Subject: Eldredge Lumber & Hardware, Inc.  
165 Presumpscot Street  
Comment Response Letter

On behalf of Eldredge Lumber & Hardware, Inc. we are pleased to address the final comments from the City of Portland, including:

- City of Portland Planning and Urban Development – Level II Site Plan Review Letter, dated October 17<sup>th</sup>, 2012.
  - Attachment 1 - Woodard & Curran – Peer Review Memo, dated October 12<sup>th</sup>, 2012.
  - Attachment 2 – Two emails from Marge Schmuckal, dated October 15<sup>th</sup>, 2012

DRAWING NO. **C-10**

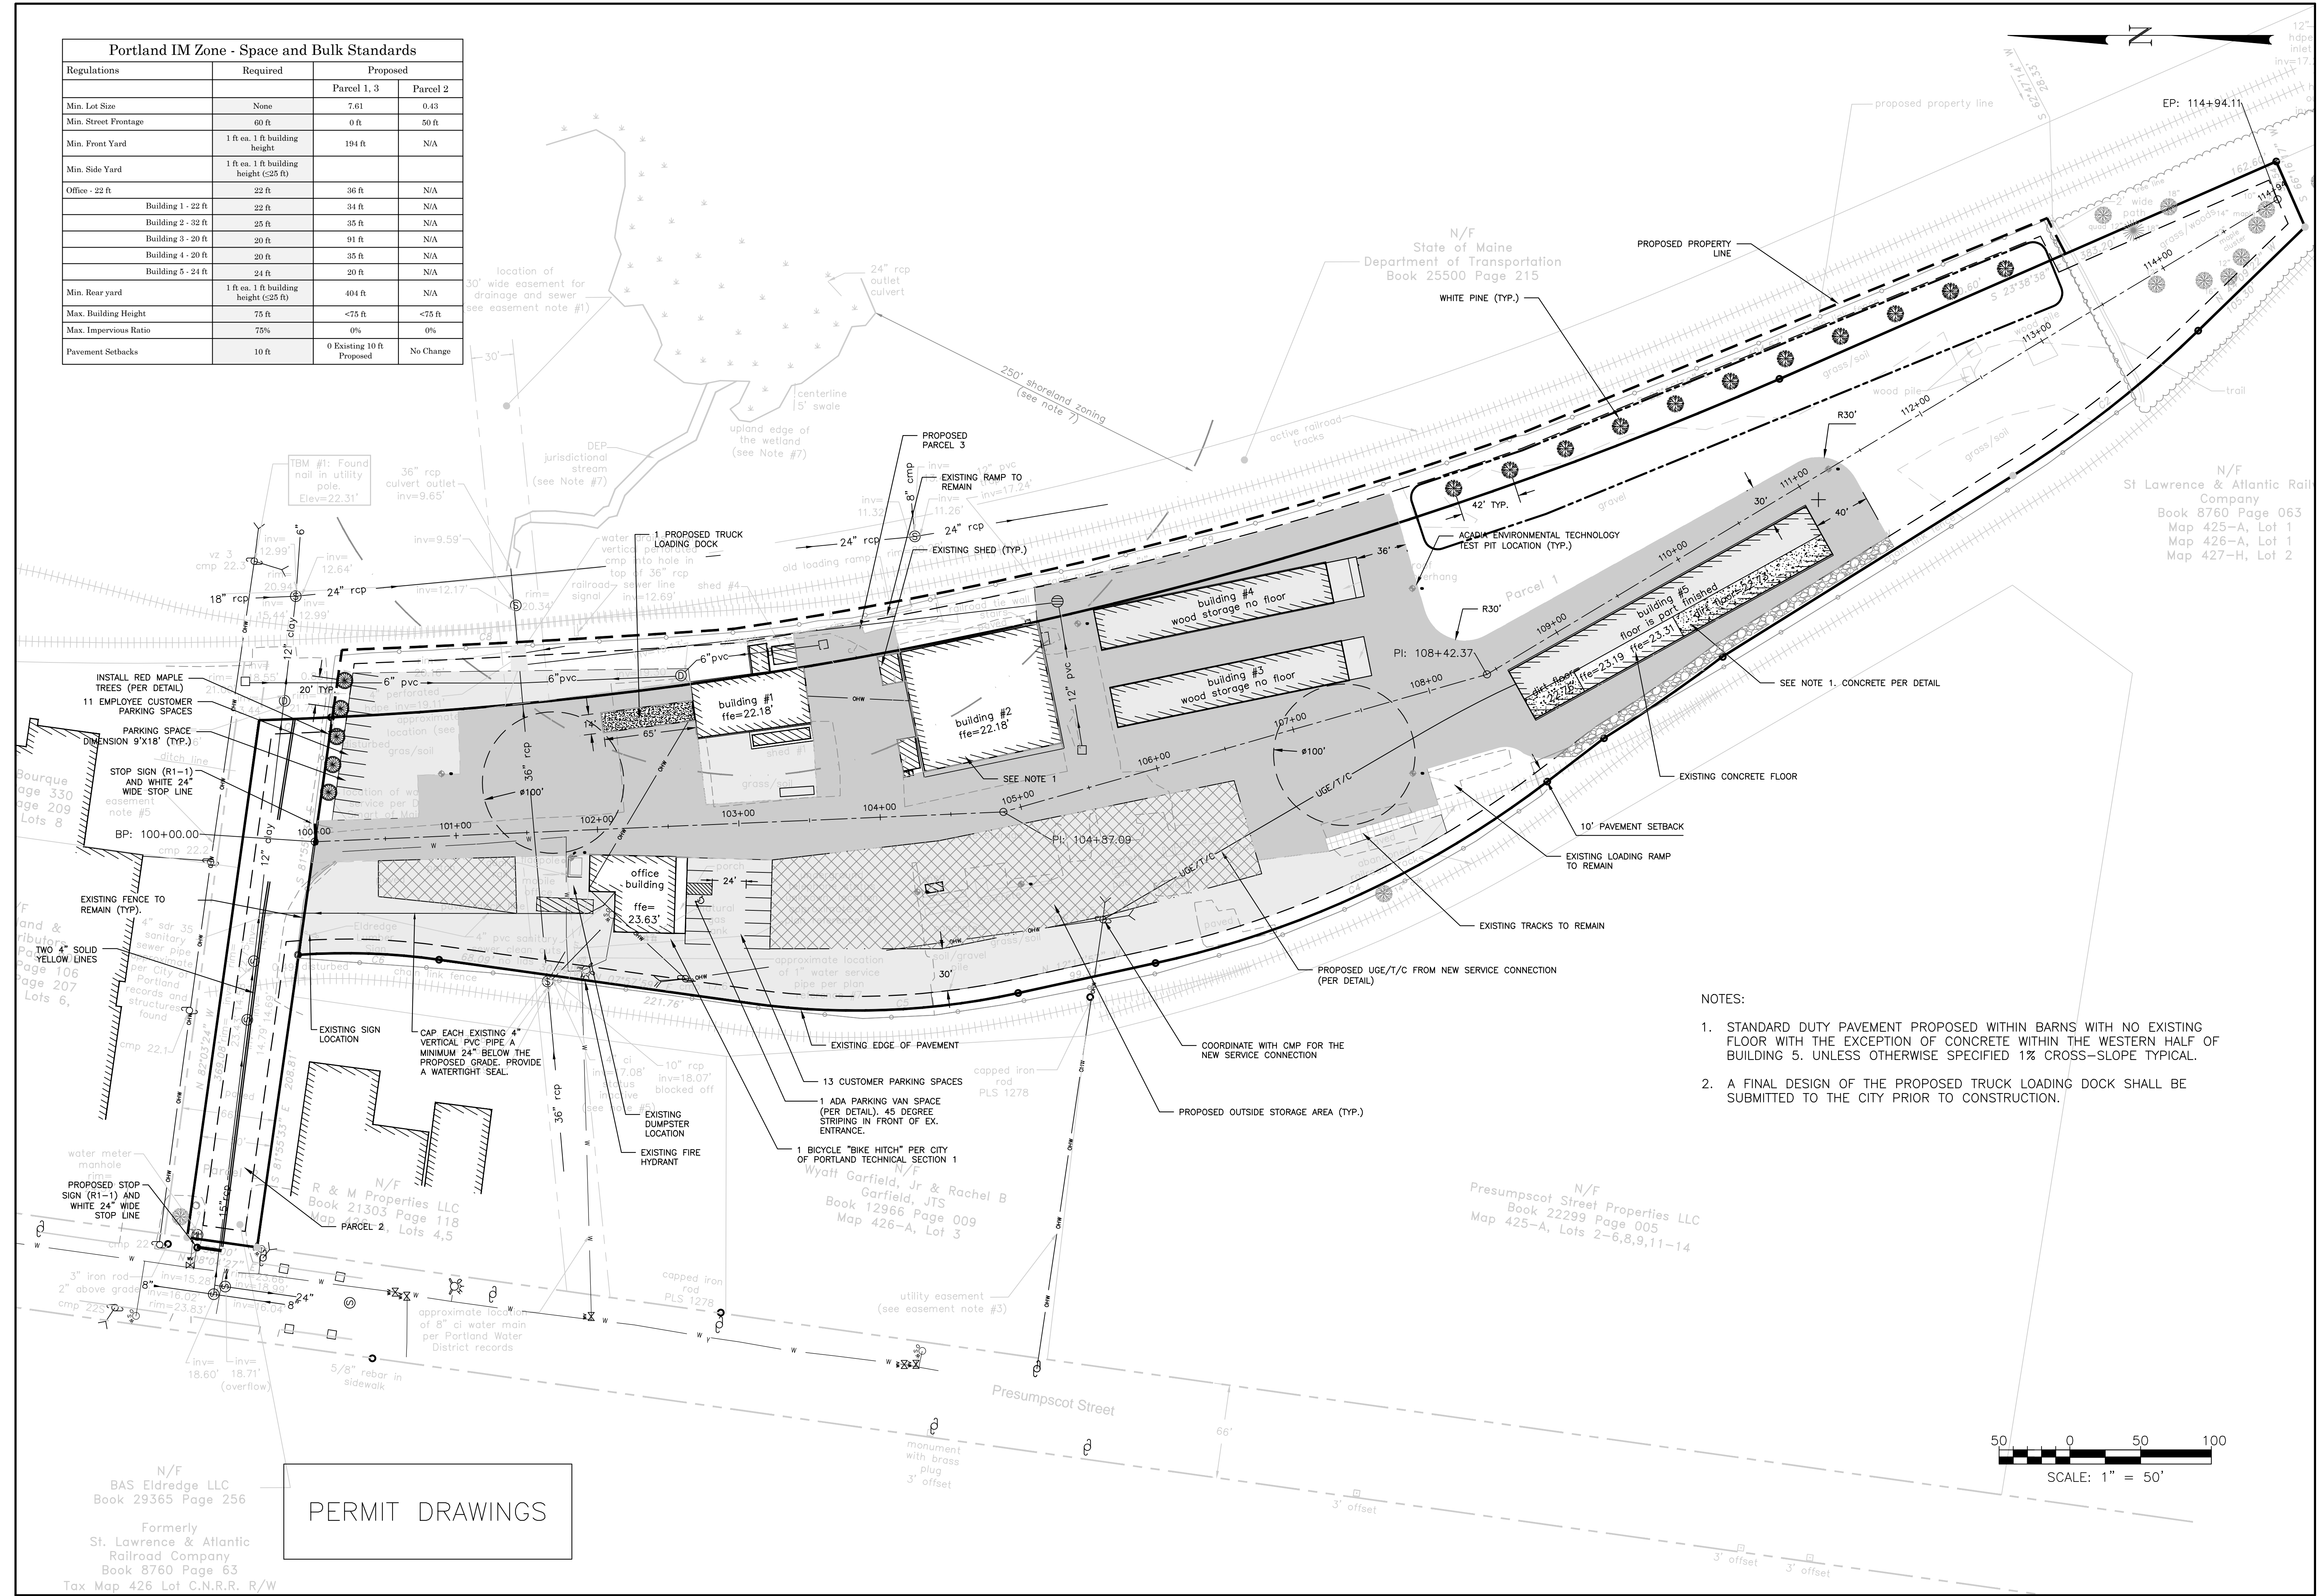
3. **Bicycle Parking:** *We note your request for a waiver of the bicycle parking requirements in the Site Plan Ordinance. A waiver is not supported as we consider that employees may wish to commute by bicycle, but we would require only 2 bicycle parking spaces (one “hitch”) rather than the 4 spaces which would be the Ordinance requirement. We support a waiver for the scooter and motorcycle parking.*

4. **Zoning:** *Thank you for the parking analysis and please revise the plans to show an additional two parking spaces to meet the zoning requirements. I attach the Zoning comments for your information since they clarify several points.*

**Response** – The Site Plan was revised to include one “hitch” to the southwest of the office/retail building.

- *The Site Plan was revised to include two additional spaces to the west of the previously provided spaces.*
  - *The applicant intends to store building supplies within the outside storage areas noted on the plans.*
  - *Separate applications will be provided for any new signage.*
5. **Landscape:**
- a. *The Ordinance clarifies that the plans need to show proposed site landscaping and screening. The southern part of the site abuts a residential zone (R-5) on the east and therefore the Ordinance Site Landscaping requirements for industrial and commercial zones would apply. In this case the proposed berm would provide some screening, but it would need to be landscaped. We suggest red or white pine tree-planting along this south-eastern edge.*

DRAWING NO. **C-20**

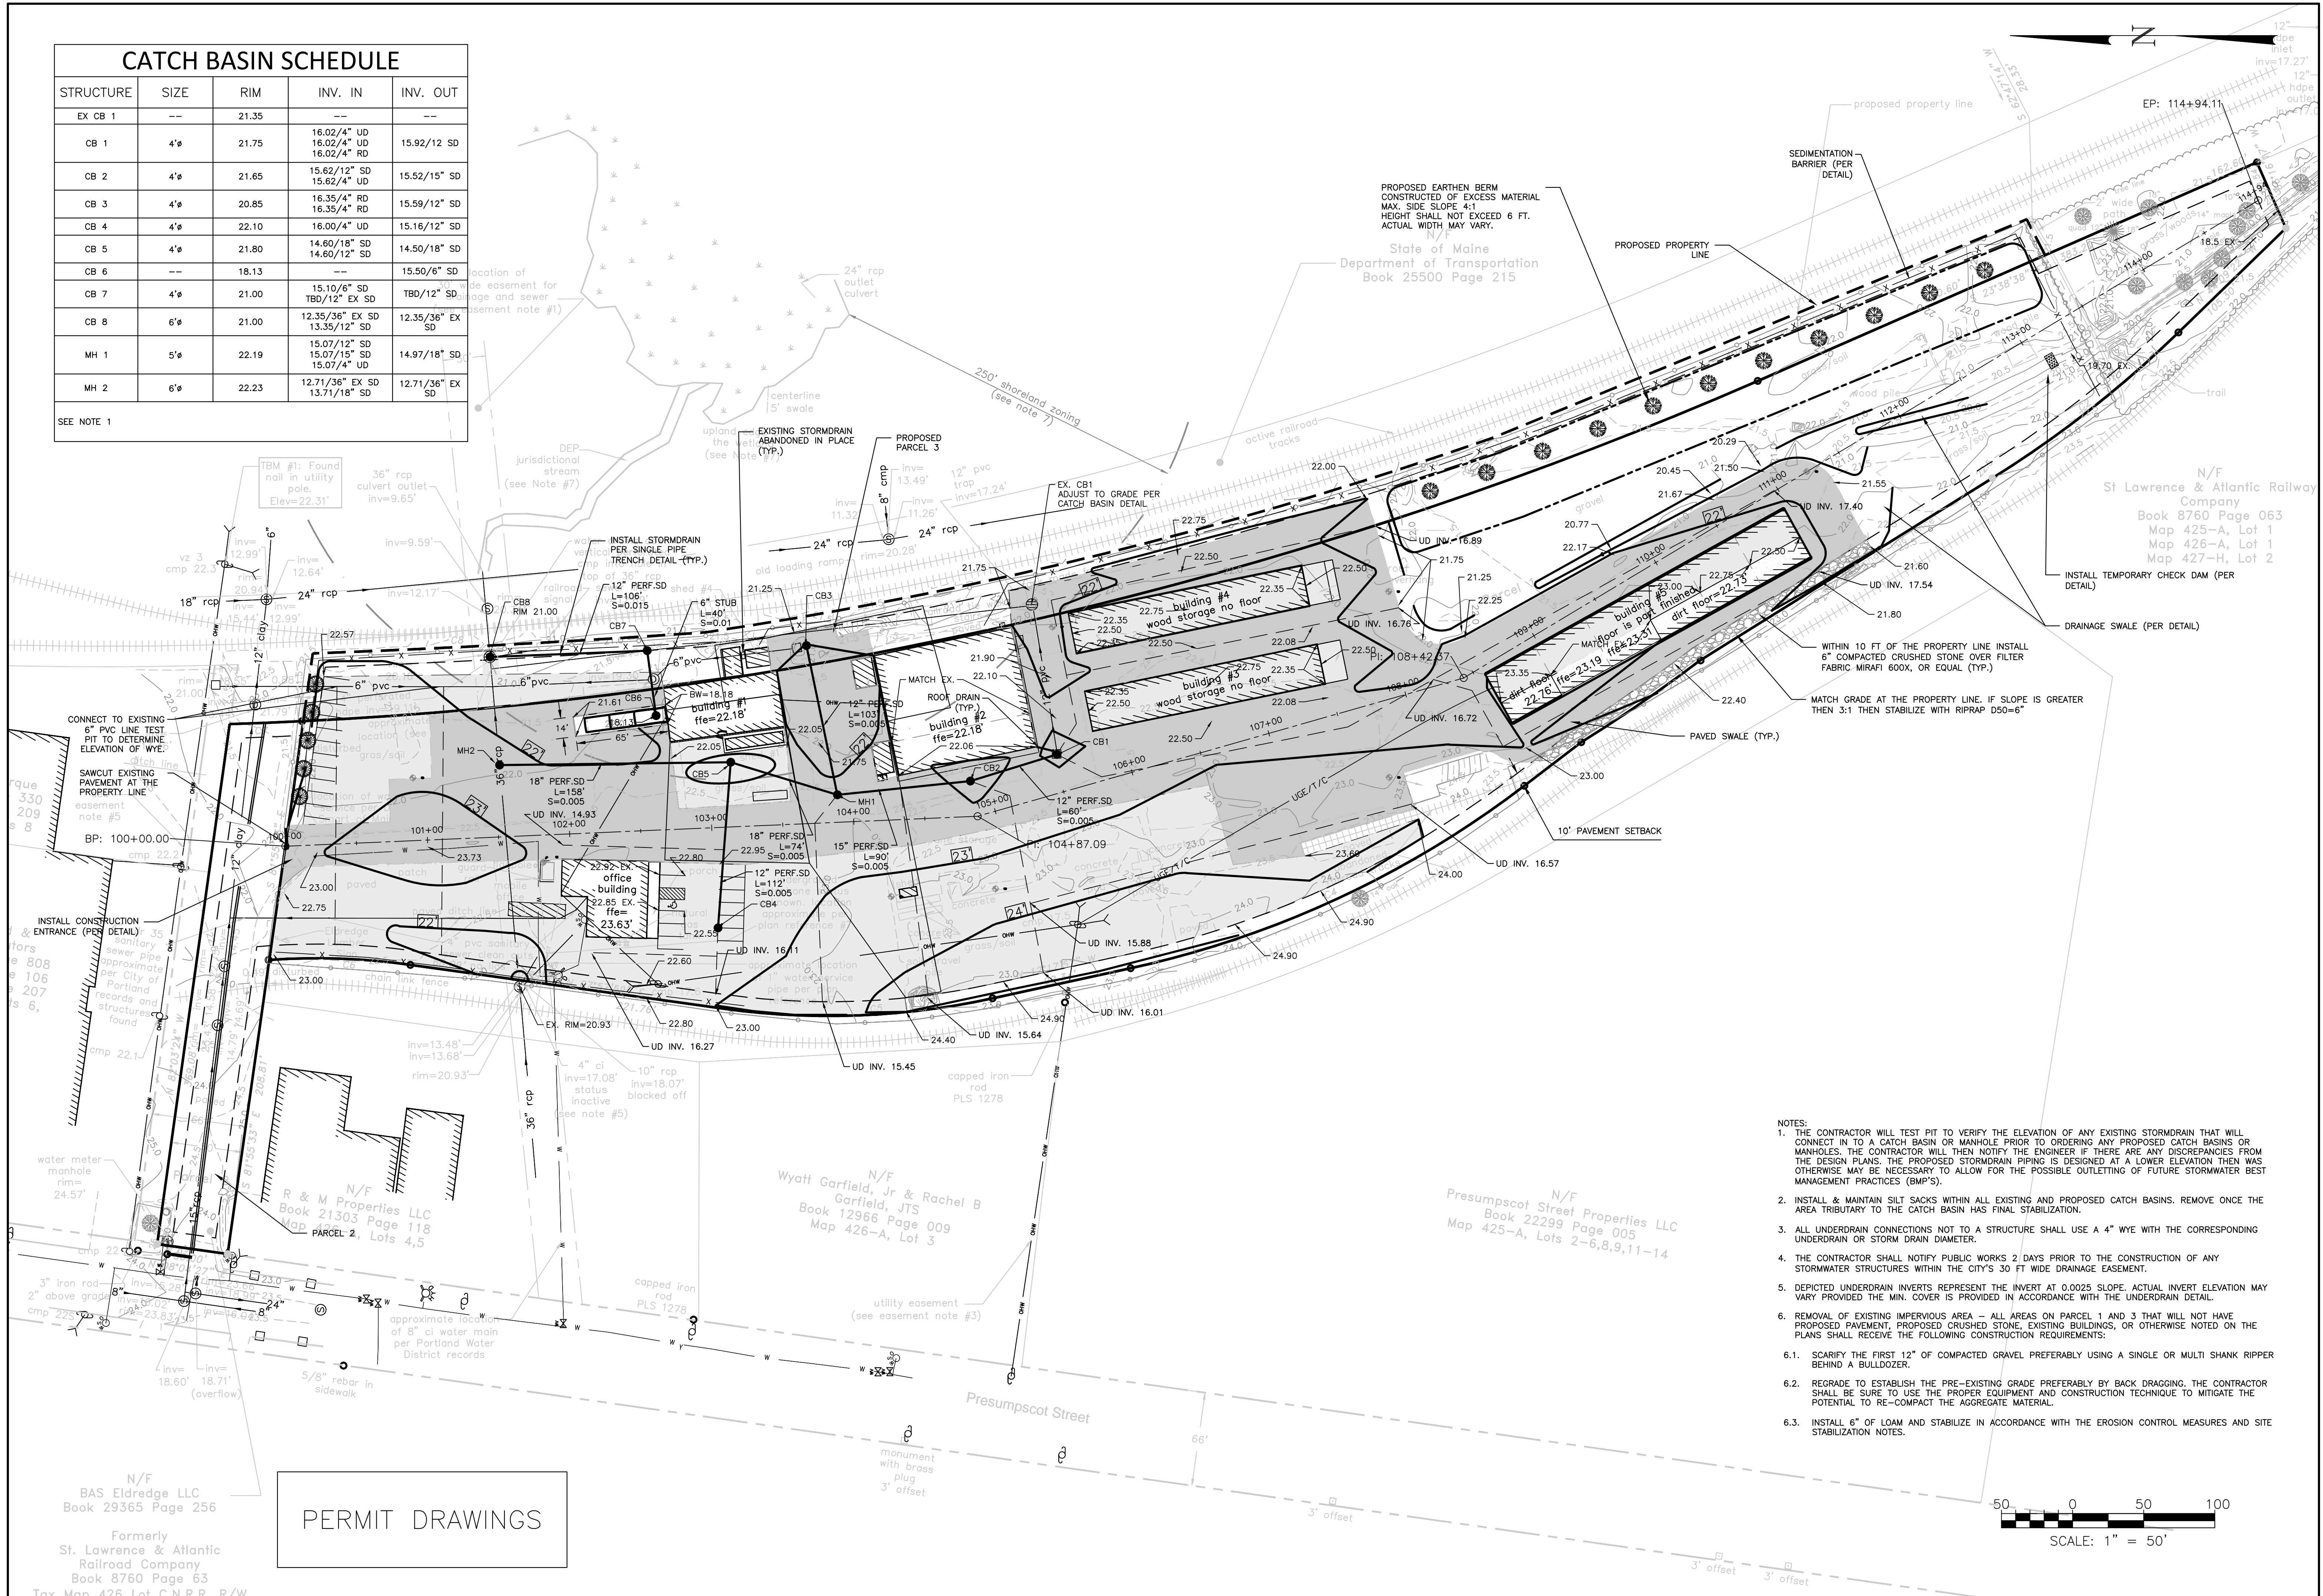
2. *The applicant is proposing two Inserta-T connections for new 12 and 18-inch storm drain pipes into an existing City-owned 36-inch RCP storm drain that crosses the site within a 30' wide easement. Per discussions with DPS, the applicant should utilize drain manhole(s) for these connections. A single drain manhole that allows for both connections would be acceptable; however, the applicant will need to verify that the pipe elevations and the configurations of the pipe penetrations can be accommodated by a single structure.*

3. *The applicant has indicated that an area of existing impervious gravel will be changed to grass, resulting in a net reduction in impervious surfaces on the site. The applicant should clarify the proposed grassed areas on the plan and should provide notes and information about the construction practice that will be utilized to vegetate the site (removal of packed gravel, depth of loam, seeded areas, erosion controls as needed, including blanket lining at swales or steep slopes).*

4. *Sheet C-20 depicts a compacted gravel swale along the west edge of the site, adjacent to and parallel with the west wall of building #5. Concentrating flow over compacted gravel will result in erosion. We understand that the applicant is attempting to maintain a 10' pavement setback from the property line in this area, but we request the applicant propose an alternate surface (crushed stone) or alternate drainage concept in this area to avoid erosion.*

**Response :** The connection to the City-owned 36" RCP storm drain was changed to reflect the peer review engineer's and DPS's comments. The proposed connections are two 6 ft diameter structures, one manhole and one catch basin. The Grading, Drainage & Erosion Control Plan was modified to reflect the associated changes. New details were also added for catch basins/manholes greater than 4 ft in diameter. The manhole to the west of Building 1 was changed from a manhole to catch basin 5. The Hydraflow Storm Sewers 2008 calculations were updated to reflect the associated changes to the storm drain, manholes and catch basins.

**Response:** The following Note 6 was added to the Grading, Drainage & Erosion Control Plan:

6. Removal of existing impervious area - all areas on parcel 1 and 3 that will not have proposed pavement, proposed crushed stone, existing buildings, or otherwise noted on the plans shall receive the following construction requirements:

- 6.1. Scarify the first 12" of compacted gravel preferably using a single or multi shank ripper behind a bulldozer.
- 6.2. Regrade to establish the pre-existing grade preferably by back dragging. The contractor shall be sure to use the proper equipment and construction technique to mitigate the potential to re-compact the aggregate material.
- 6.3. Install 6" of loam and stabilize in accordance with the erosion control measures and site stabilization notes.

**Response:** The Grading, Drainage & Erosion Control Plan was updated to include 6" of compacted crushed storm over filter fabric 600x within 10 ft of the property line adjacent to Building 5.

TREE PLANTING DETAIL
NOT TO SCALE

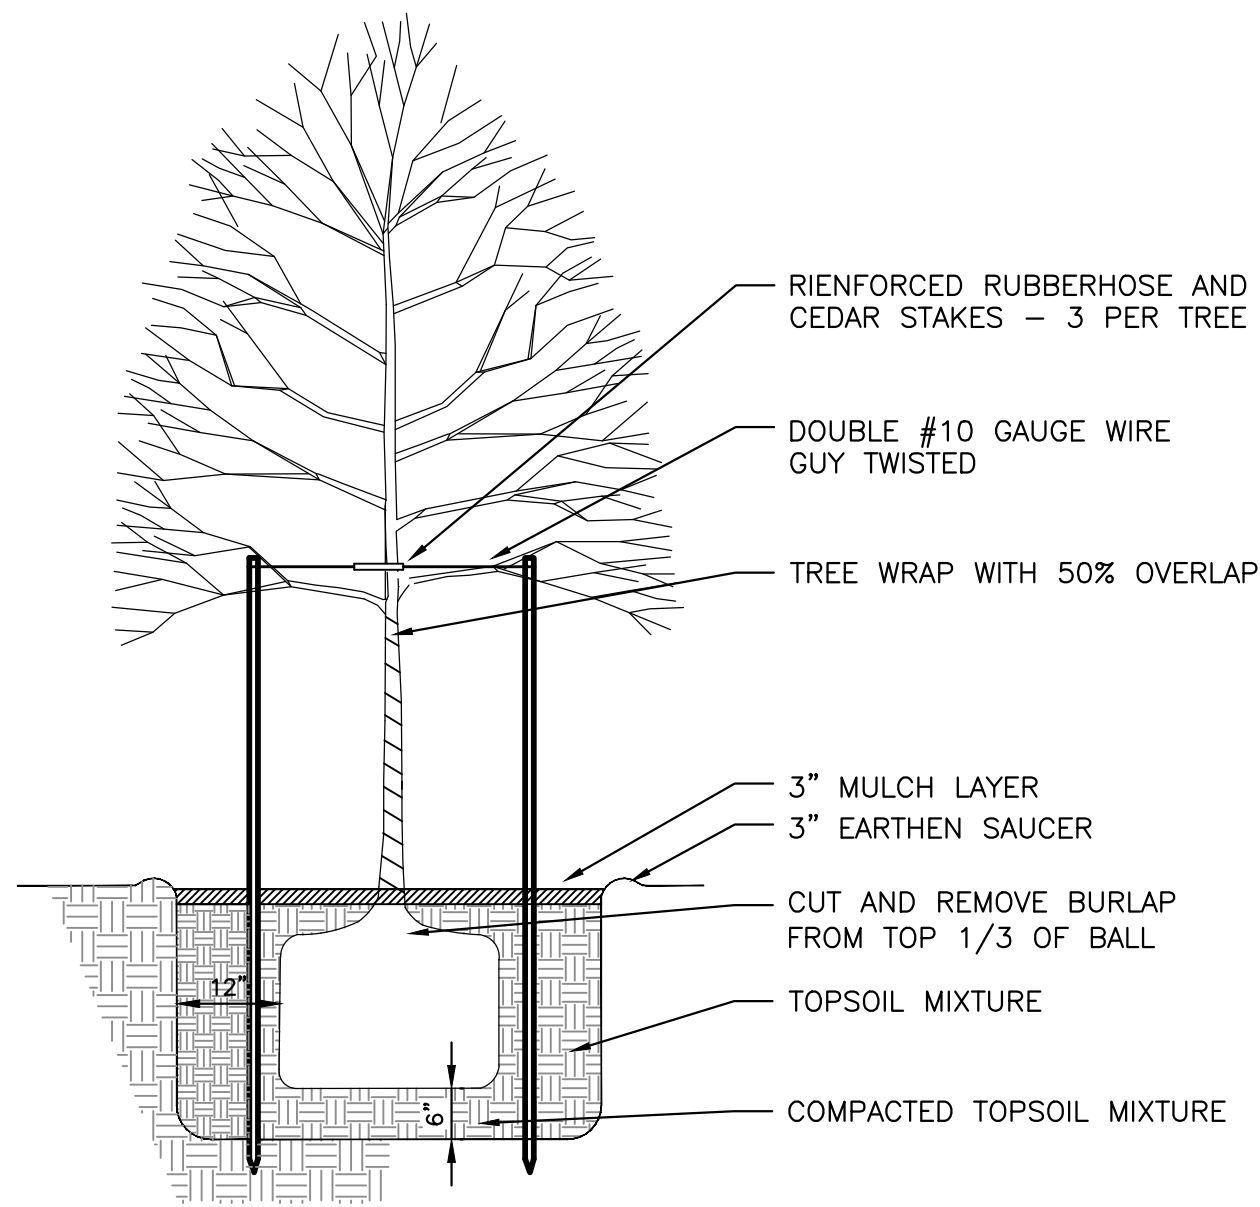
- b. *The Ordinance requirements for parking lot landscaping (see Landscaping and Landscape Preservation: Parking Lot Landscaping) applies to all parking on the site, not just to additional parking. Please add tree planting to the site plan along the front of the identified parking nearest to the access drive and railway; red maples are suggested.*

- c. All planting should meet the requirements of the above referenced Ordinance provisions and the City of Portland Technical Manual Section 4.*

**Response:** Eleven Red Pine trees were added to the proposed earthen berm spaced every 42 feet. Please refer to the Site Layout plan for locations and the Tree Planting Detail on Sheet C-32, for further information.

**Response:** Five Red Maples were added between the proposed parking spaces and the private roadway spaced every 20 ft. Please refer to the Site Layout plan for locations and the Tree Planting Detail on Sheet C-32, for further information.

**Response:** Please refer to the Tree Planting Detail on Sheet C-32. The notes specify that all plant installation and selection will be in compliance with the City of Portland Technical Manual Section 4.
